From: Simon Davis
Sent: 08 July 2020 12:30
To: Planning Scanning
Subject: FW: Yapton - Drove Lane Design Code - Update

From: Simon Davis
Sent: 08 July 2020 12:28
To: Sparkes, Jessica [REDACTED]
Subject: RE: Yapton - Drove Lane Design Code - Update

Dear Jessica and Zoe,

Indicative illustrations of Village Street

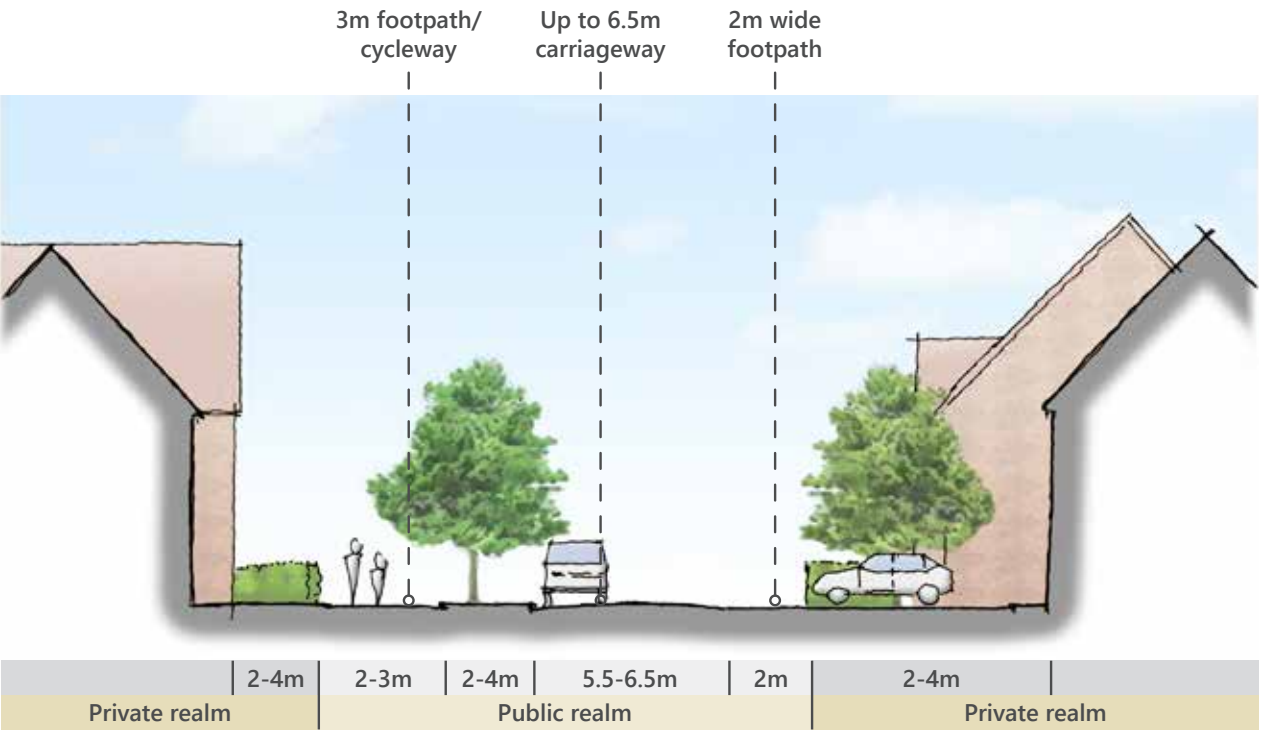
The main street description in the Design Code refers to a 2m verge on both sides of the carriageway and includes the caveat 'where appropriate to the setting' – This is not clear. I believe we raised this previously. The residential streets box in the Design Code states 'possible street trees' – you need to remove 'possible'. In terms of Lanes and also drives, the Design Code is confusing as the image has 'shared surface' but the text has tarmac which does not suggest a welcoming shared surface environment. We note that the Outline DAS showed lanes and drives as shared surfaces with block paving.
